From: Zoe Toppin <Zoe.Toppin@arun.gov.uk>
Sent: 04 May 2021 10:43
To: Planning.Responses <Planning.Responses@arun.gov.uk>
Subject: FW: EP/16/21/PL

Client: Mr D Lynch		
Project Address: The Garage The Way East Preston		
Drawing Title: Existing and Proposed Plans and Elevations		
Drawing Number: 1241.01.g		
Scale:	As stated printed @ A1	
Date:	06/01/2020

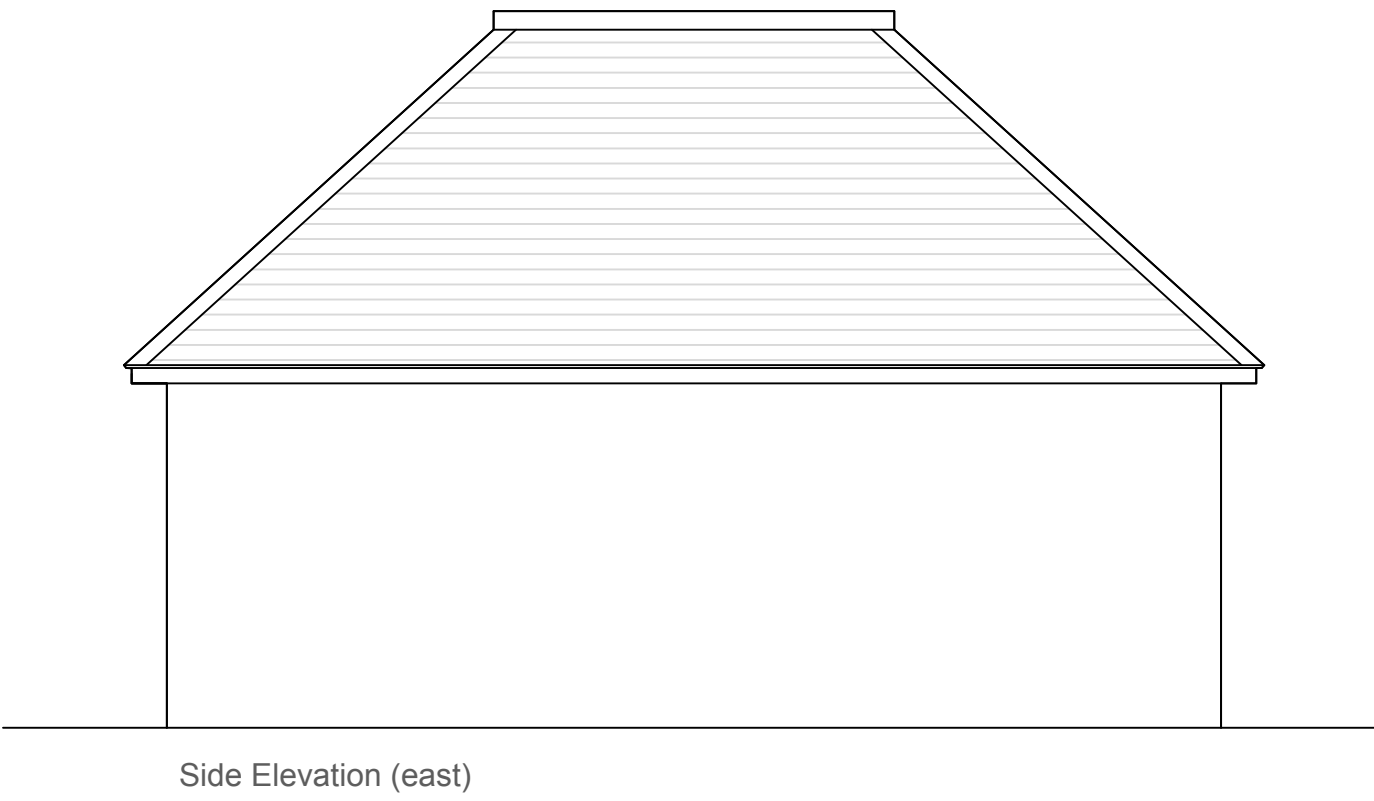
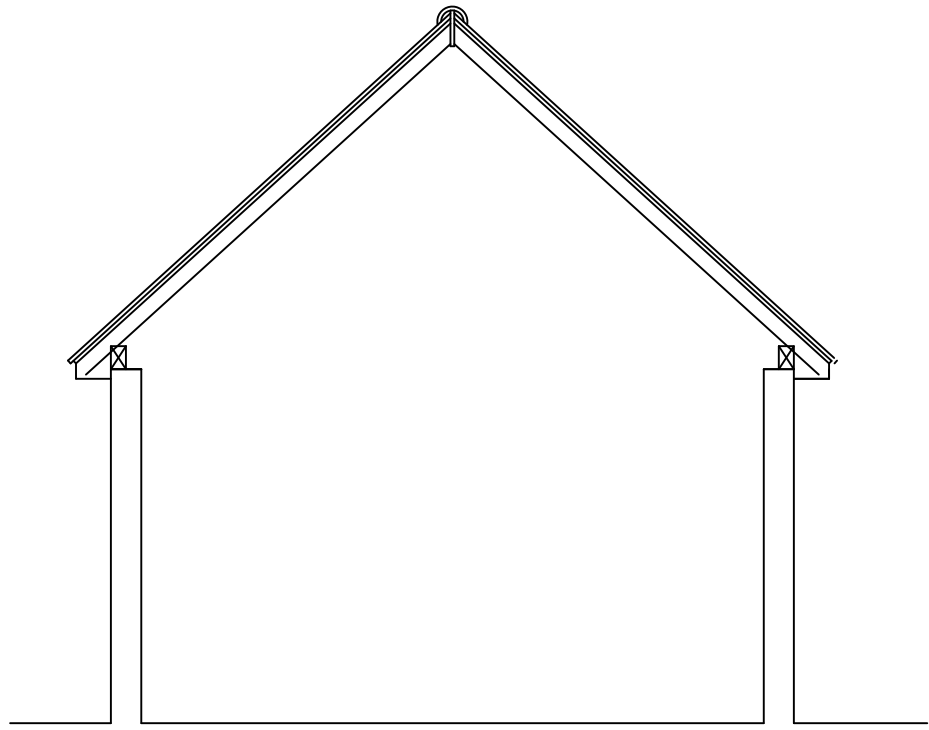
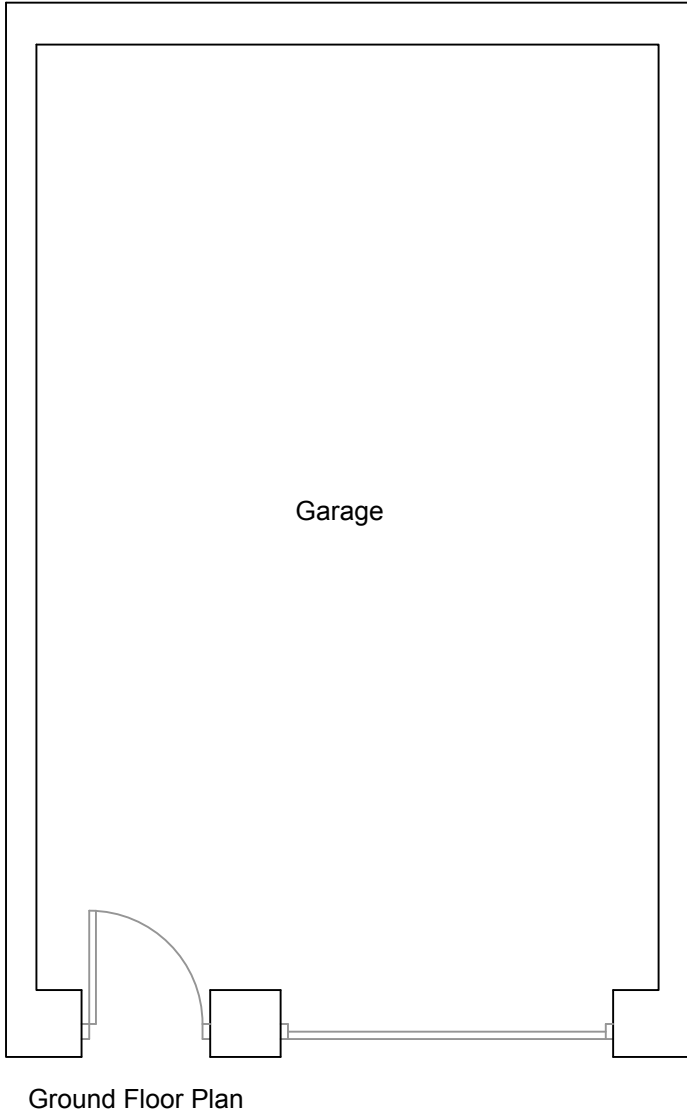
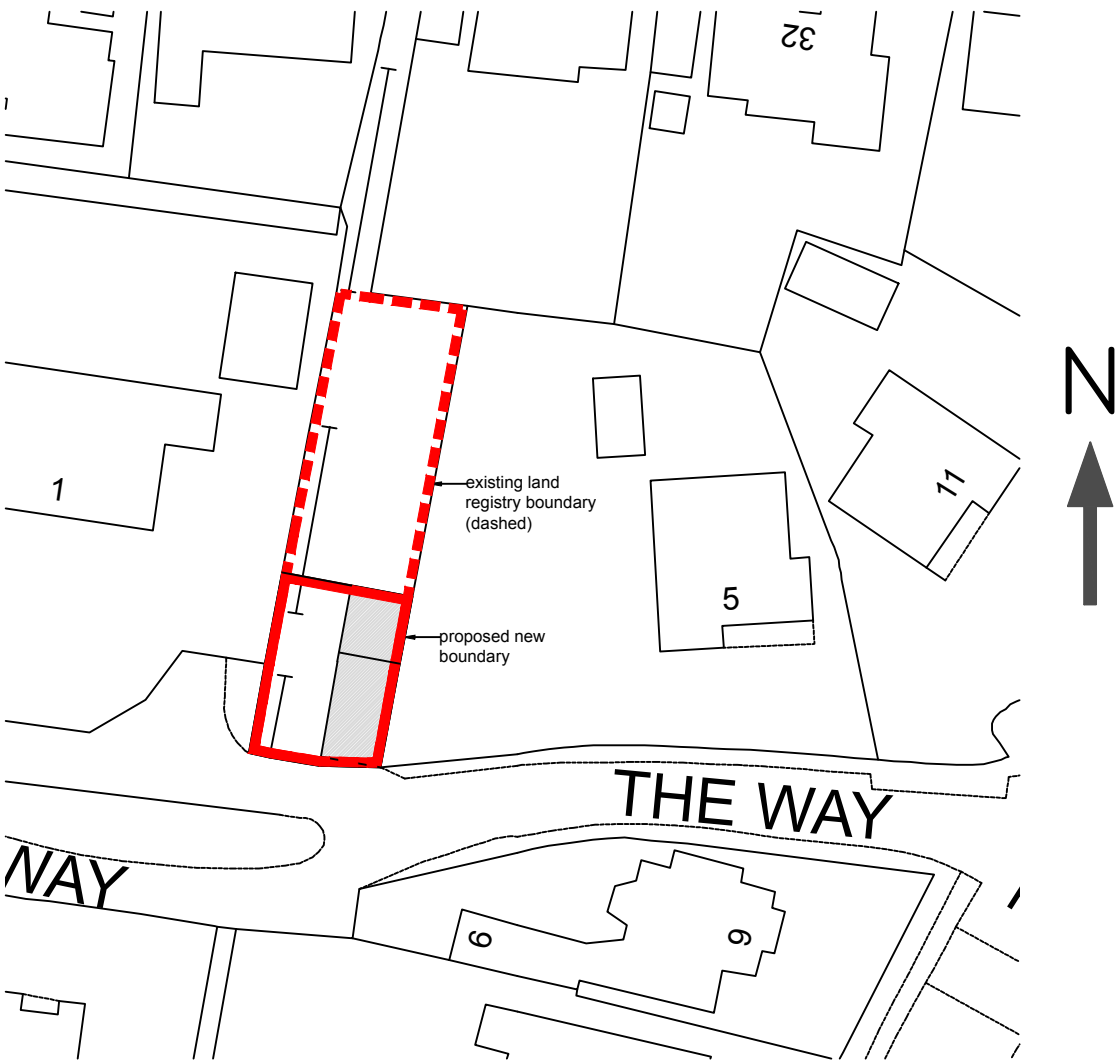
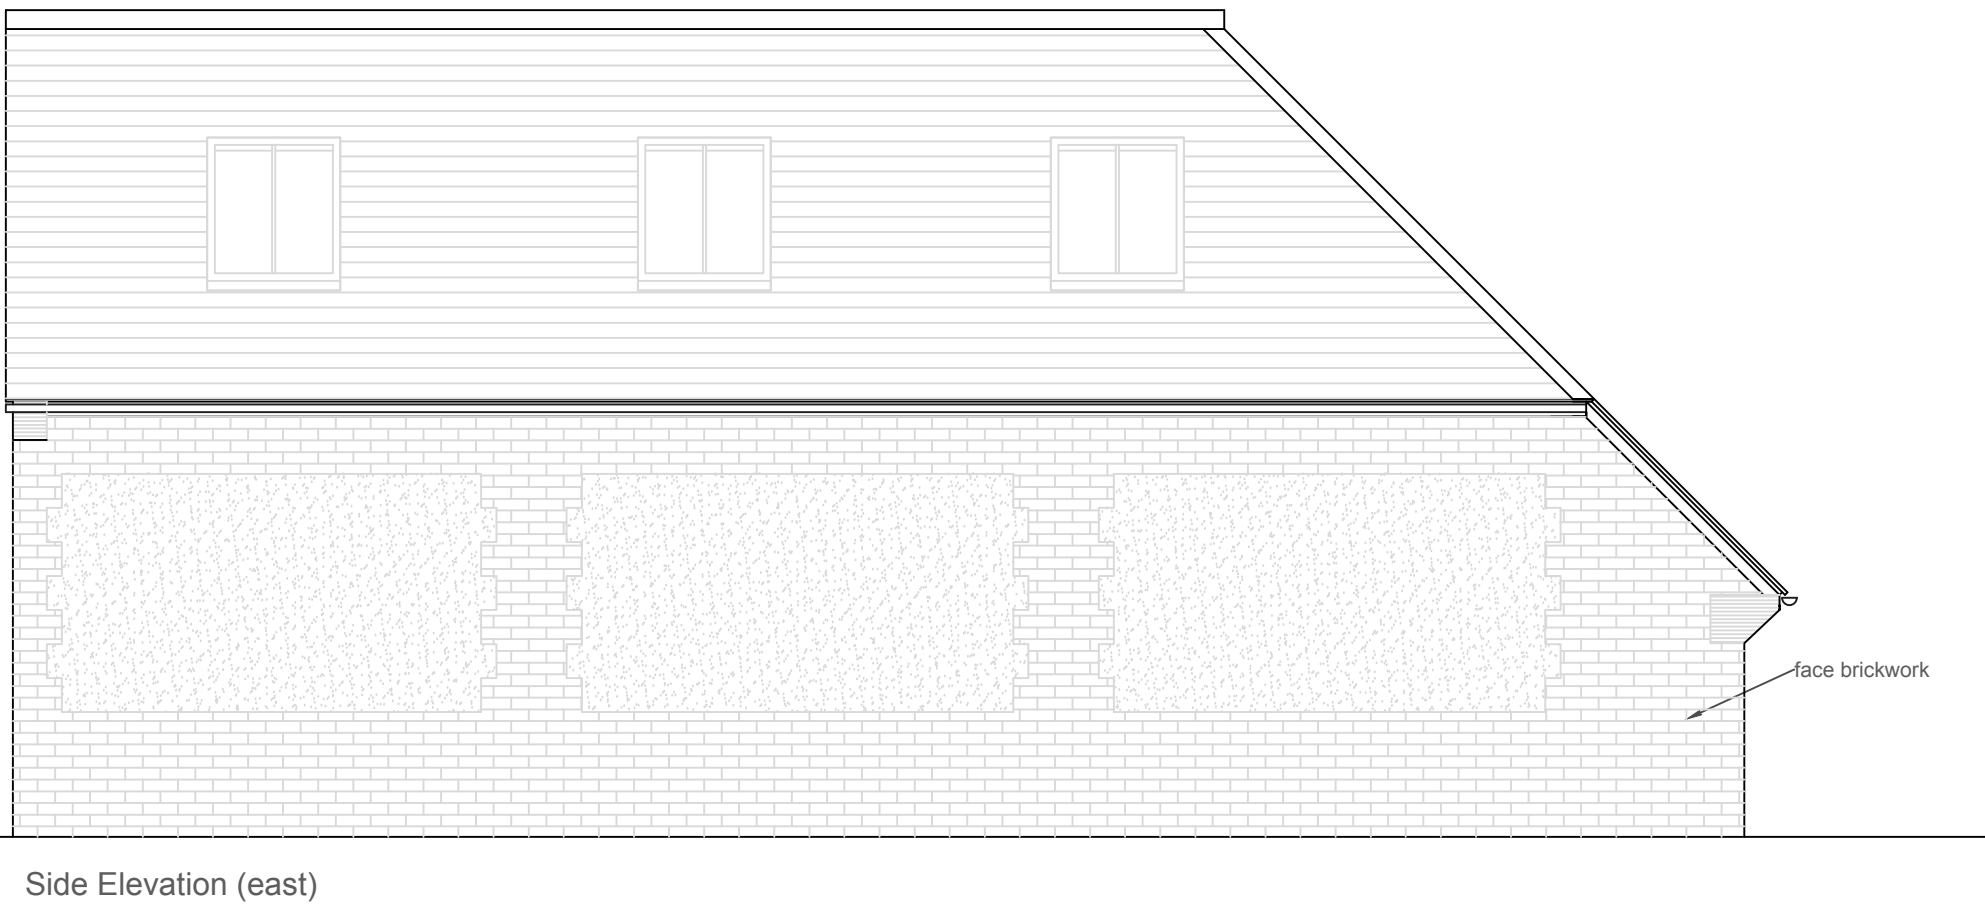
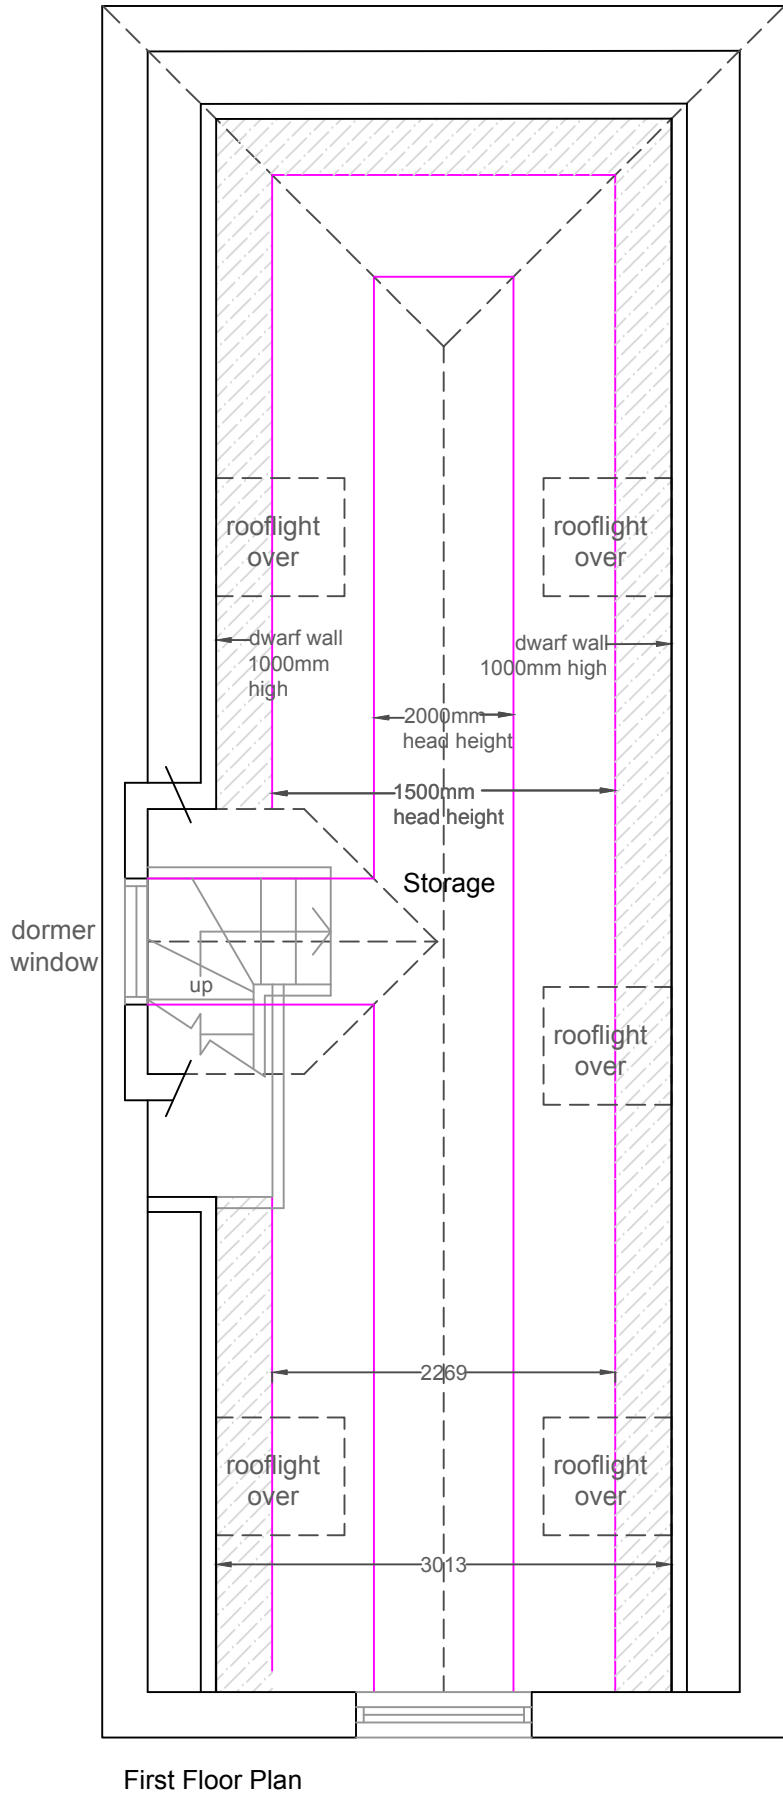
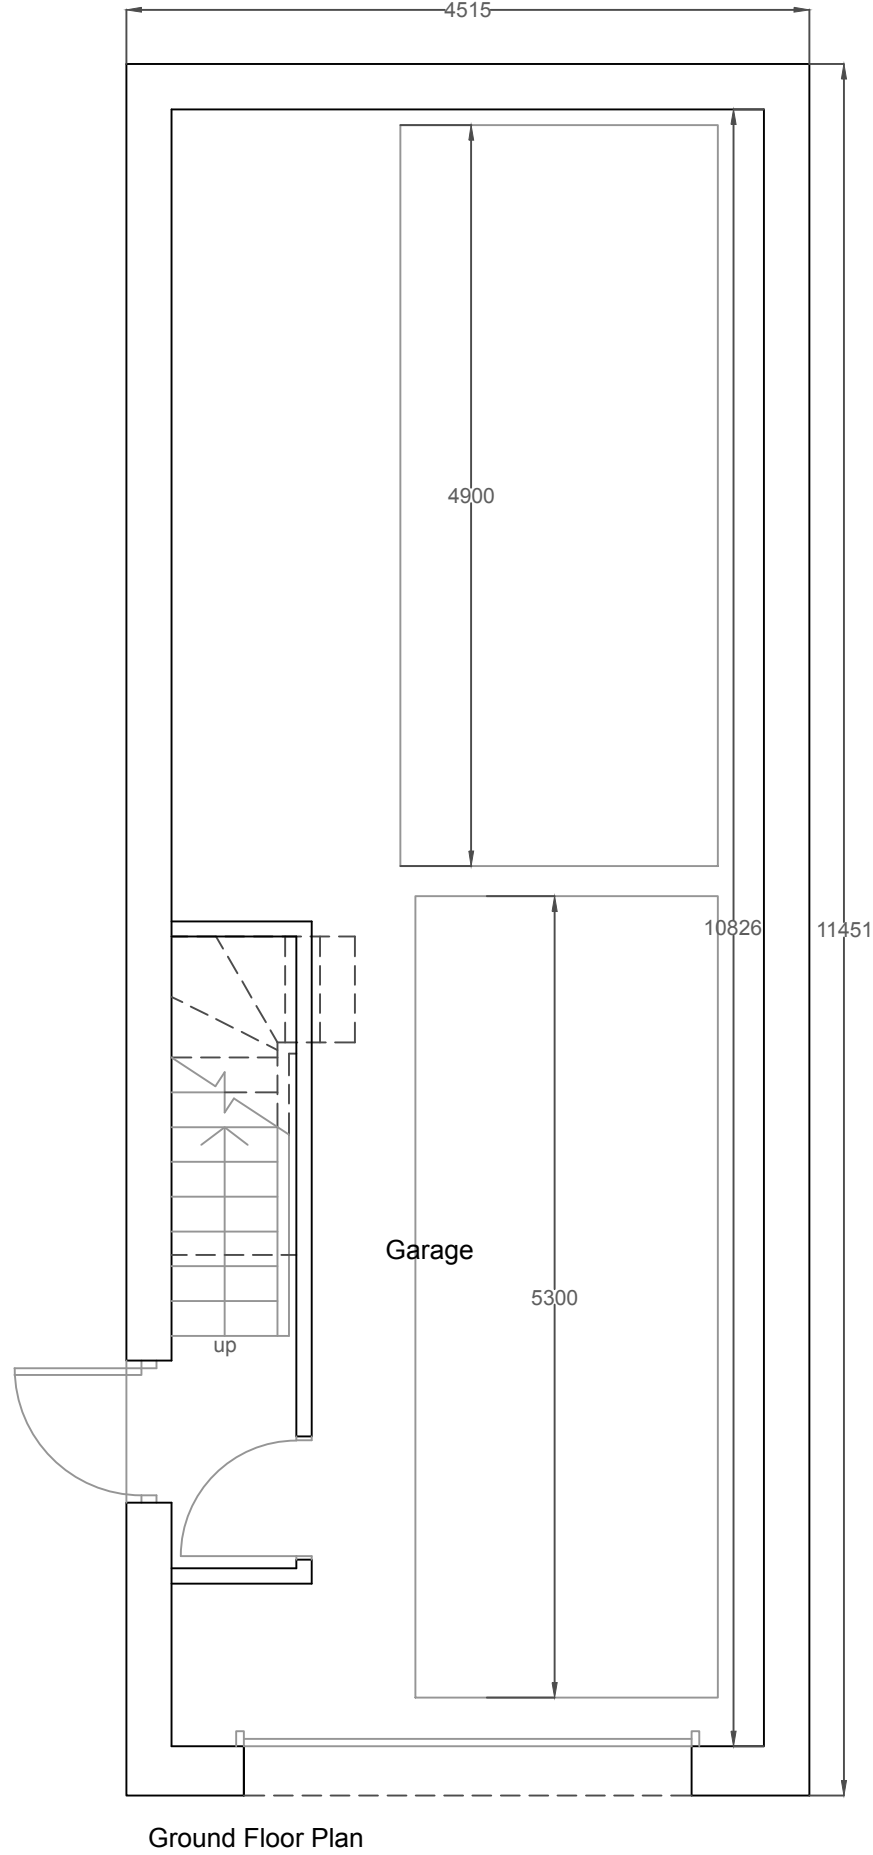
There has been a condition added to this application to show the three windows on the side (east) elevation of the garage will be permanently obscurely glazed and fixed shut up to a height of 1.7m from the finished floor level in order to protect the private amenity to the neighbours at the east. Please can you provide a plan to show this with a cross section from the ground to 1.7m to show the windows will be obscurely glazed and fixed shut up to a height of 1.7m.

There has also been concerns of why a dormer would be necessary for a garage if it is to be used as storage. As a result, it would be necessary to remove the dormer to the garage for this proposal. Please provide amended plans to show the dormer has been removed.

The three windows on west elevation should also be removed from the proposal as the garage will be used for storage there is no necessary need for windows, this will also create amenity issues.

1. An amended plan for the east elevation to show the cross section from the ground to 1.7m to show the windows will be obscurely glazed and fixed shut up to a height of 1.7m.
2. An amended plan to show the dormer has been removed.
3. An amended plan for the west elevation to show the three windows to be removed from the proposal

I have removed the dormer and reduced the number of roof lights. I have also reduced the size of the roof lights and positioned them so the cill of the roof lights are 1.7m from finished floor level so there is no overlooking. I have included a section to demonstrate the position of the roof lights.

I have reverted to a hipped roof at the rear of the building which is as per the pre-application advice scheme. I have done this in order to accommodate the staircase and still provide space for the two cars in the garage.
